July 7, 2025

RE: Preliminary Plat – Winrock Town Center

Sketch Plat Comments

ROAD A
2100 LOUISIAN BLVD NE
ALBUQUERQUE, NM

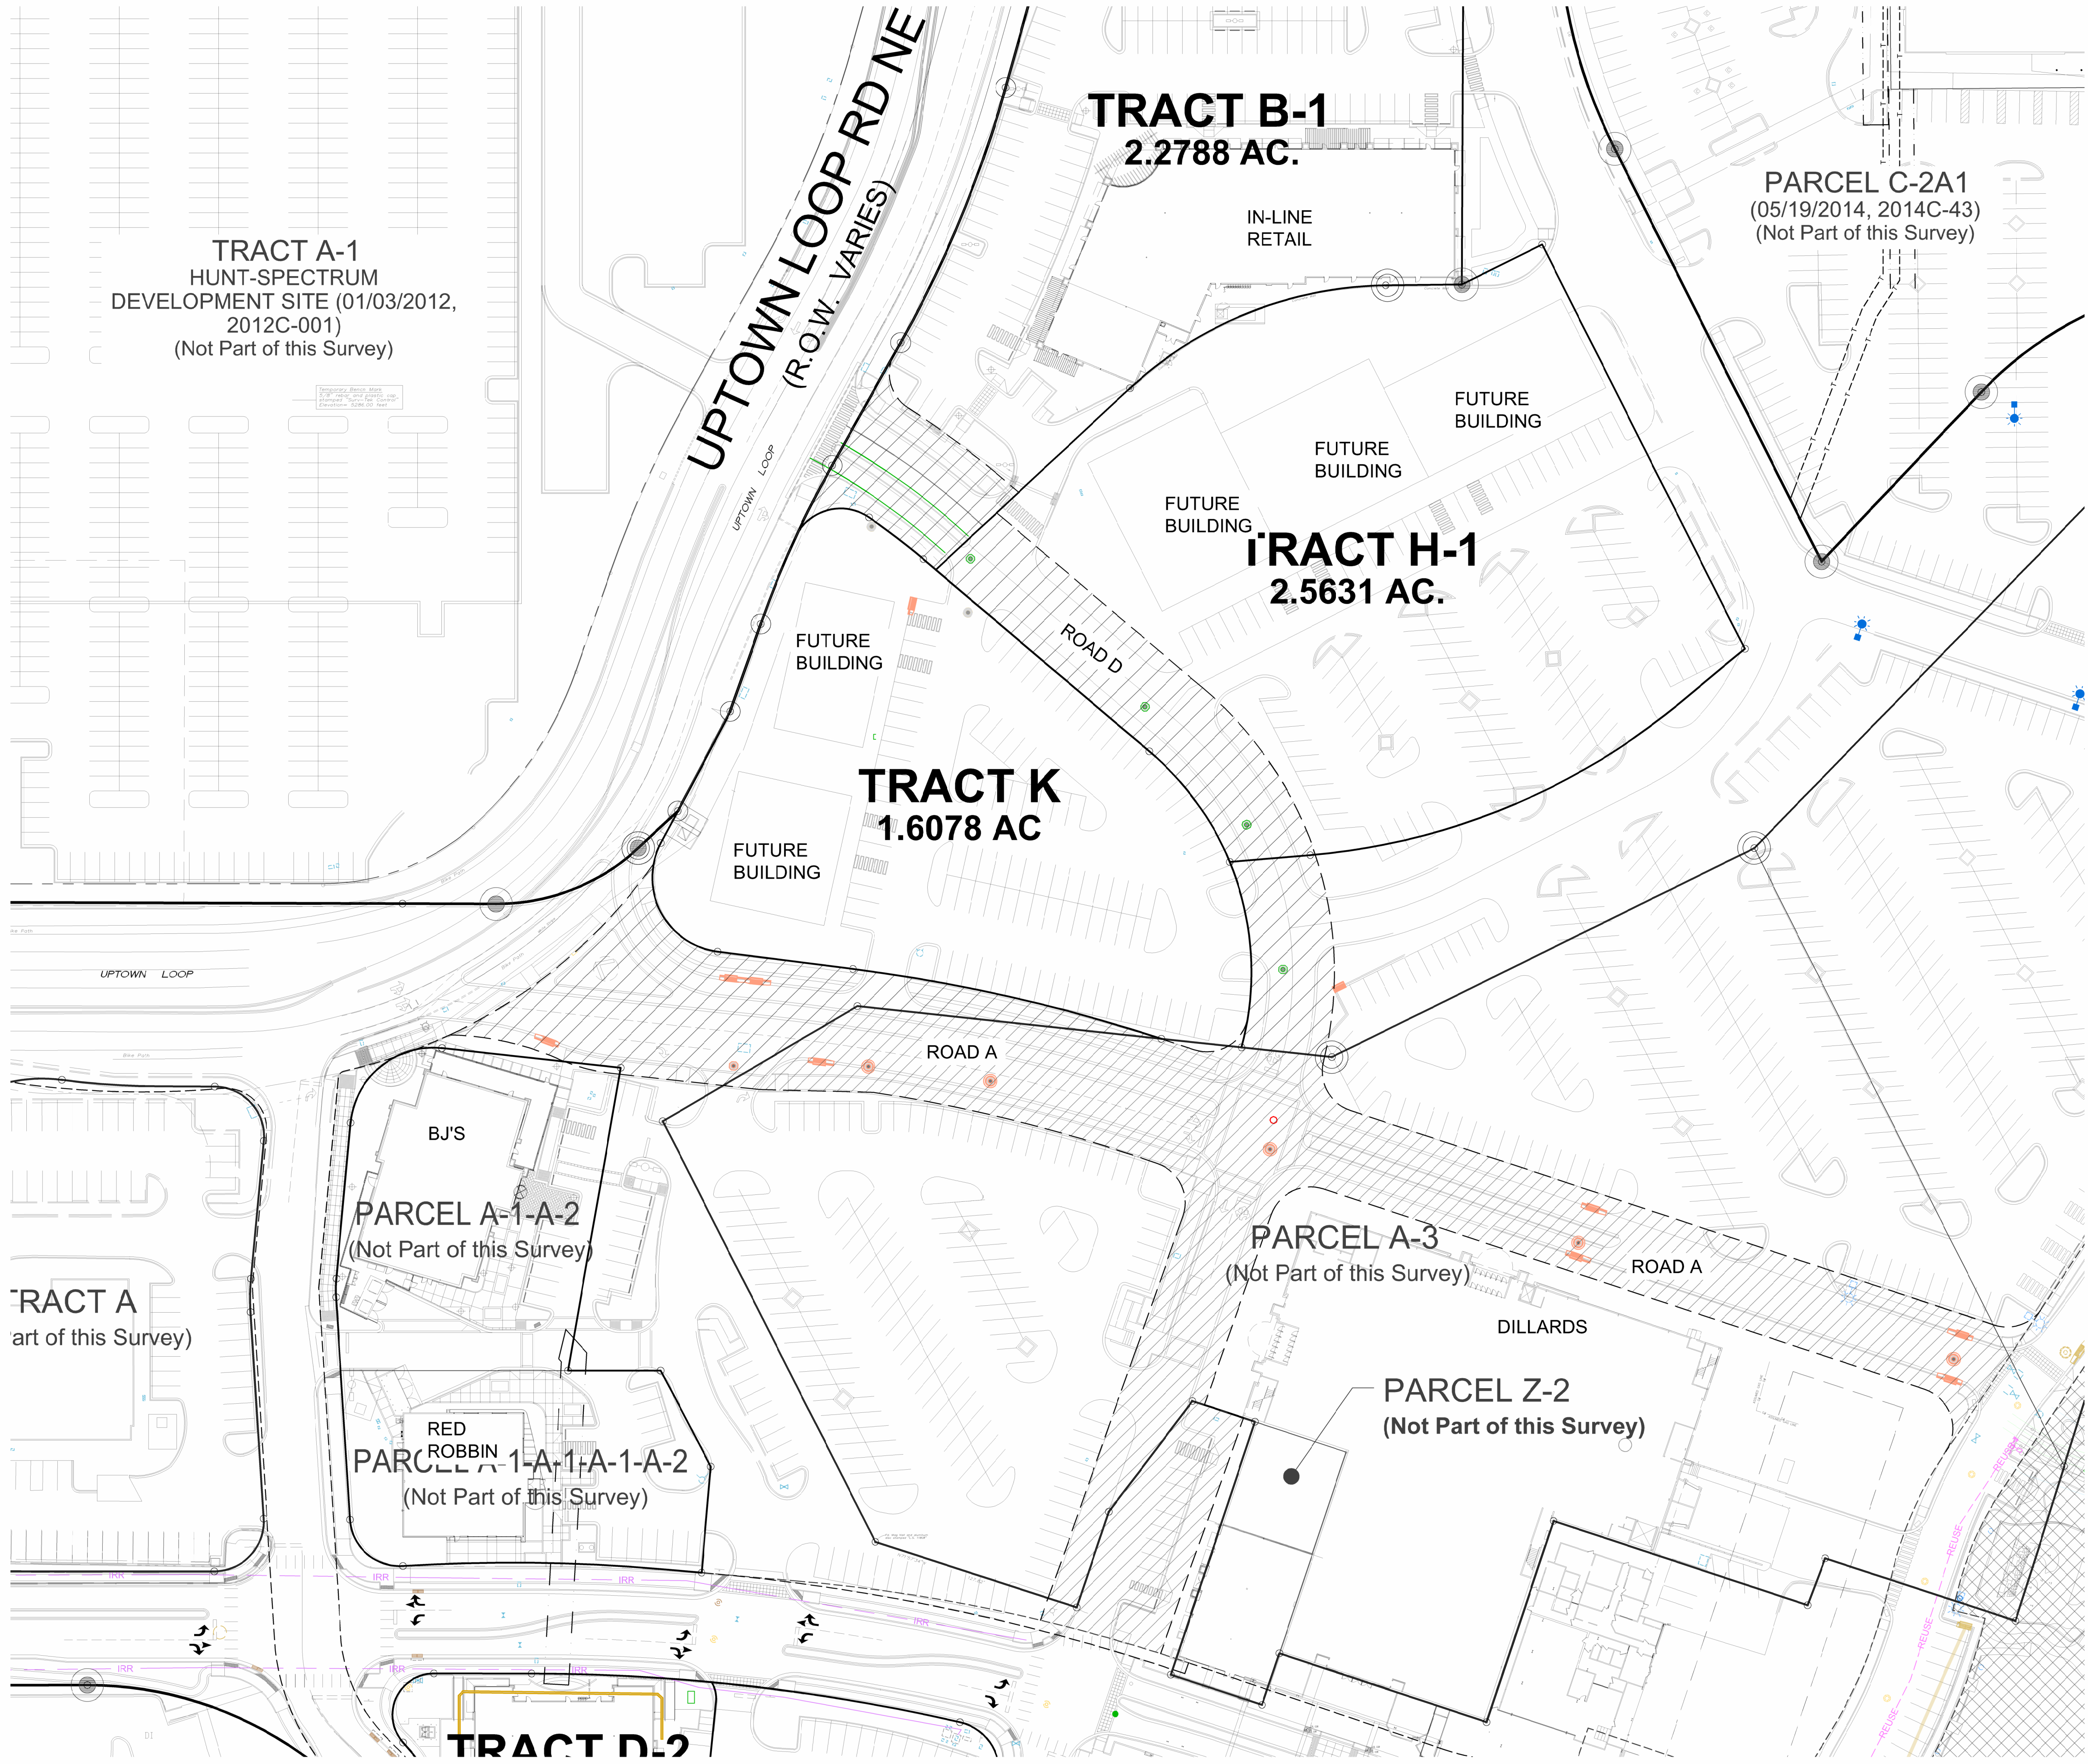
1. Louisiana is a Principal Arterial within a Center and requires 10’ sidewalk with a 6’ to 8’ landscape buffer. All other adjacent roads are private and require 5’ sidewalks. Please provide dimensions of all existing sidewalks and buffers to determine if widening is required.

3. Louisiana is a Principal Arterial within a Center and requires 10' sidewalk with a 6' to 8' landscape buffer. All other adjacent roads are private and require 5' sidewalks.

Applicant Response: See attachment named “Sidewalk Exhibit” and “SITE SKETCH”.

Applicant Response: See attachment named "Sidewalk Exhibit" and "SITE SKETCH".
